Content:
UPLOADEDhttps://majorprojects.affinitylive.com/?action=view_activity&id=69749Submission for Job: #6010 SSD 6010 - One Residential Building (Student Accommodation) within Darling Drive Plot
https://majorprojects.affinitylive.com/?action=view_job&id=6010Site: #2824 SICEEP Site, The Haymarket; Darling Drive, Sydney
https://majorprojects.affinitylive.com/?action=view_site&id=2824

SSD 6010 - One Residential Building (Student Accommodation) within Darling Drive Plot

30 July 2013

SHADOW DIAGRAMS: PERSPECTIVE, SHOWING THE PEAK, WINTER SOLSTICE

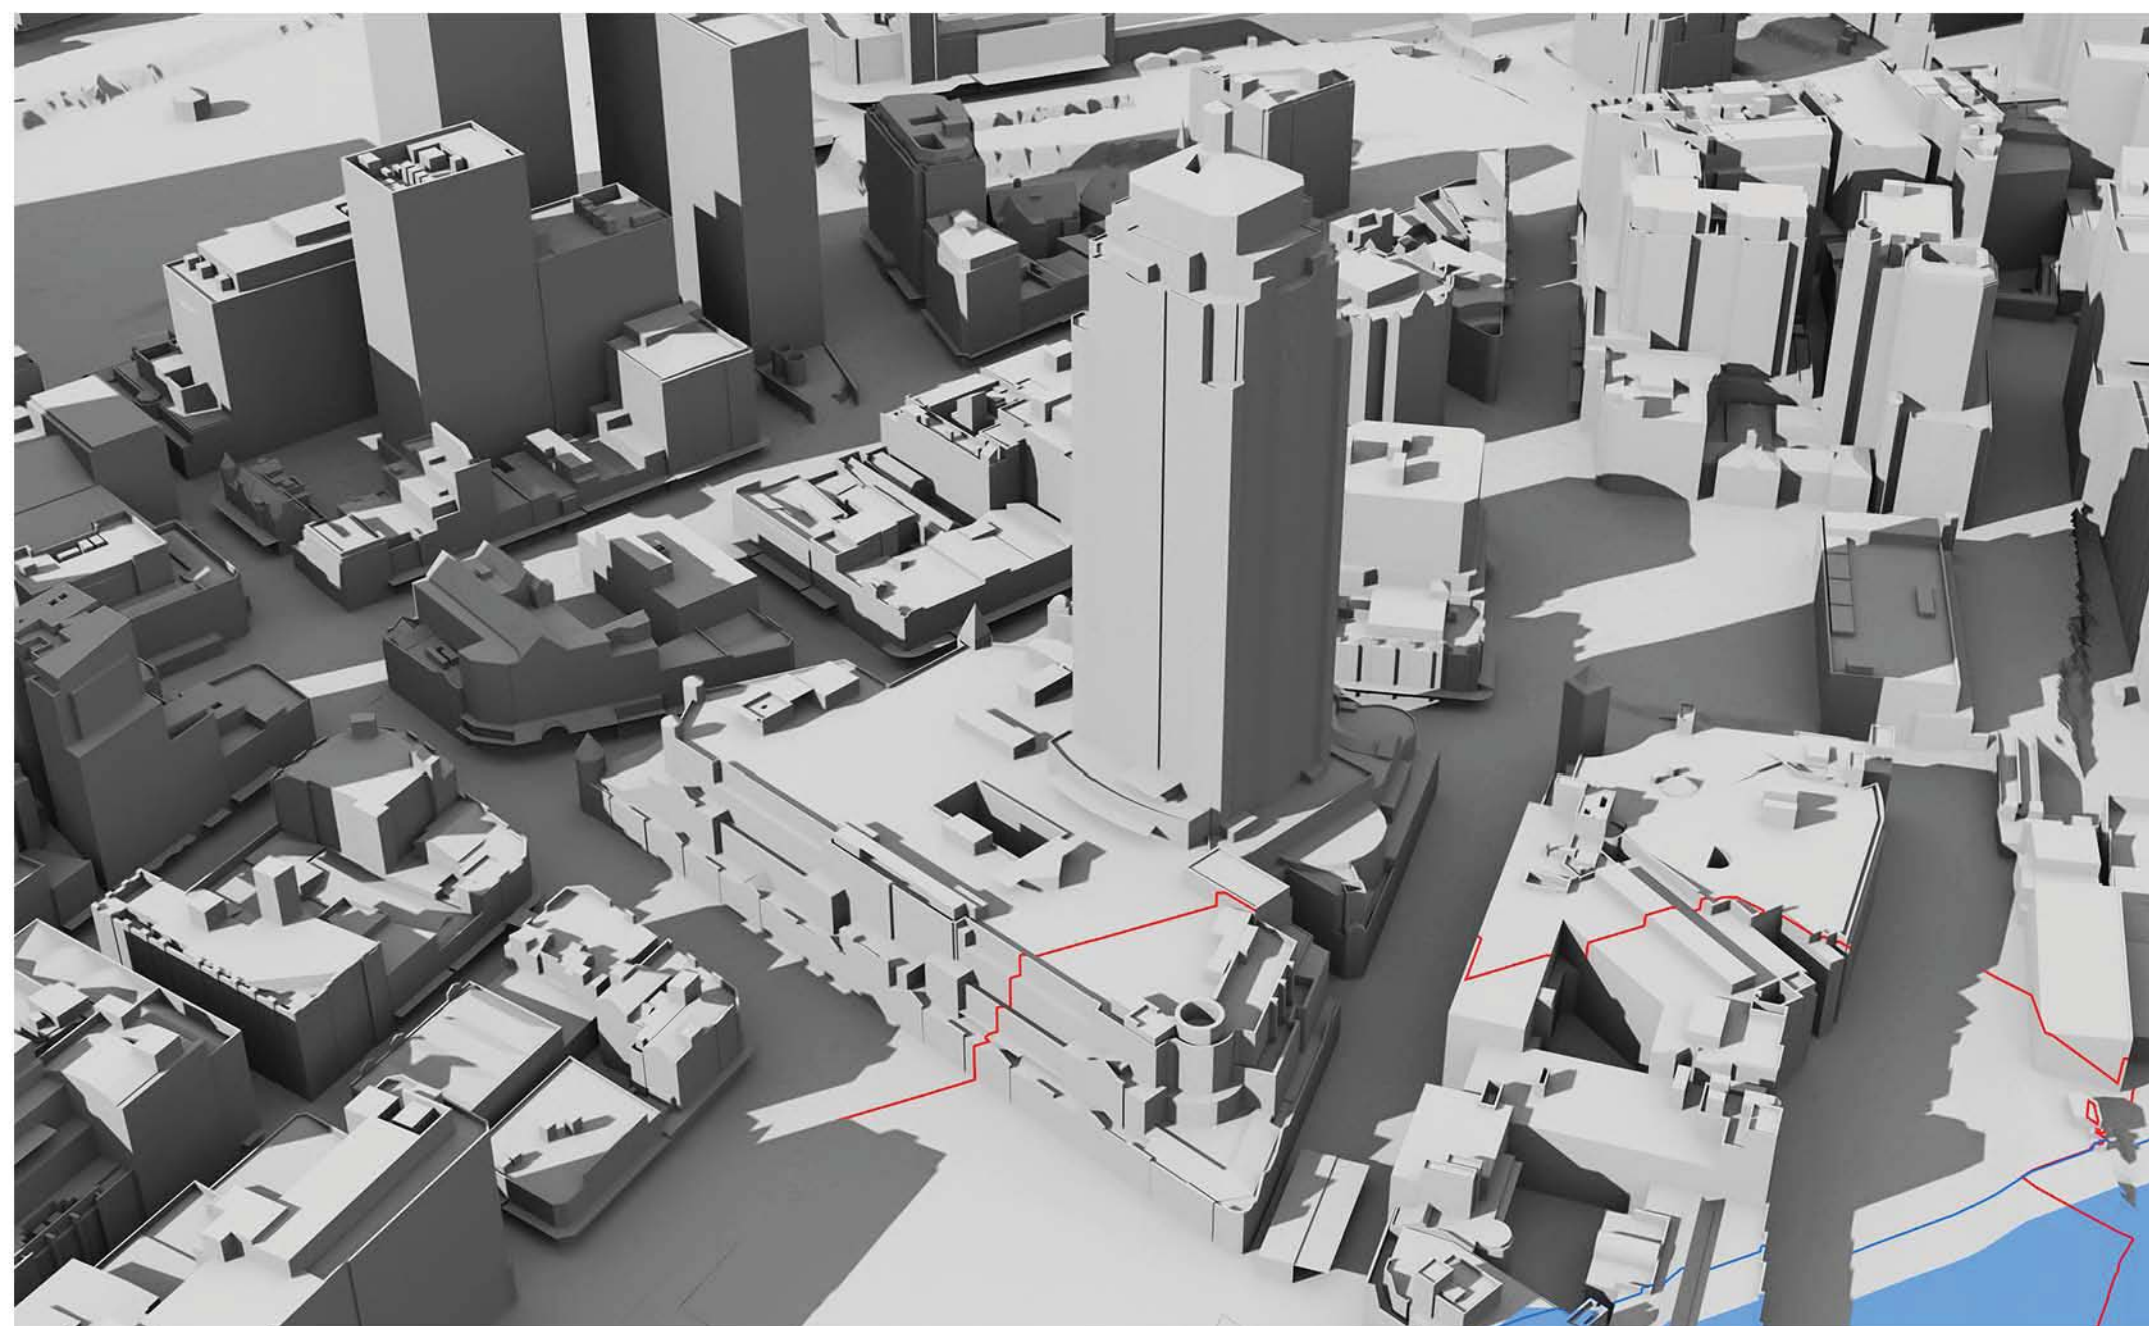
At 9am, 10am and 11am the west façade is totally in shadow due to other parts of The Peak building itself.

At 12pm there is still substantial existing shadowing on the west façade caused by the irregular shape of the west facade.

At 1pm the existing shadowing has been substantially removed, but not totally removed.

It can be concluded that some single aspect apartments on the west façade and some south-west dual aspect corner apartments currently receive less than 2 hours direct sunlight to habitable rooms and 50% of the private open space between 9am and 3pm on 21 June.

By 2pm the existing shadowing has been totally removed, but that is too late to achieve two hours of direct sunlight before 3pm.

At 9am, 10am and 11am the west façade is totally in shadow due to other parts of The Peak building itself.

At 12pm there is still substantial existing shadowing on the west façade caused by the irregular shape of the west facade.

At 1pm the existing shadowing has been substantially, although not entirely, removed. However, overshadowing of lower levels of the west façade by the concept proposal parameter plan shadows for the N,NE and SE plots has already started.

By 2pm the existing shadowing has been totally removed. However, overshadowing of the west façade by the SSDA4 and SSDA5 buildings has appeared and risen further up the west façade than the concept proposal parameter plan shadows for the N,NE and SE plots, which is still present.

It can be concluded that, as a result of combination of the proposed development with existing shadowing of the west façade, some single aspect apartments on the west façade and the south-west dual aspect corner apartments which currently receive less than 2 hours direct sunlight to habitable rooms and 50% of the private open space between 9am and 3pm on 21 June will suffer additional overshadowing. It is beyond our skills to count the number of such apartments. We note that the proponent has made no attempt to do so.
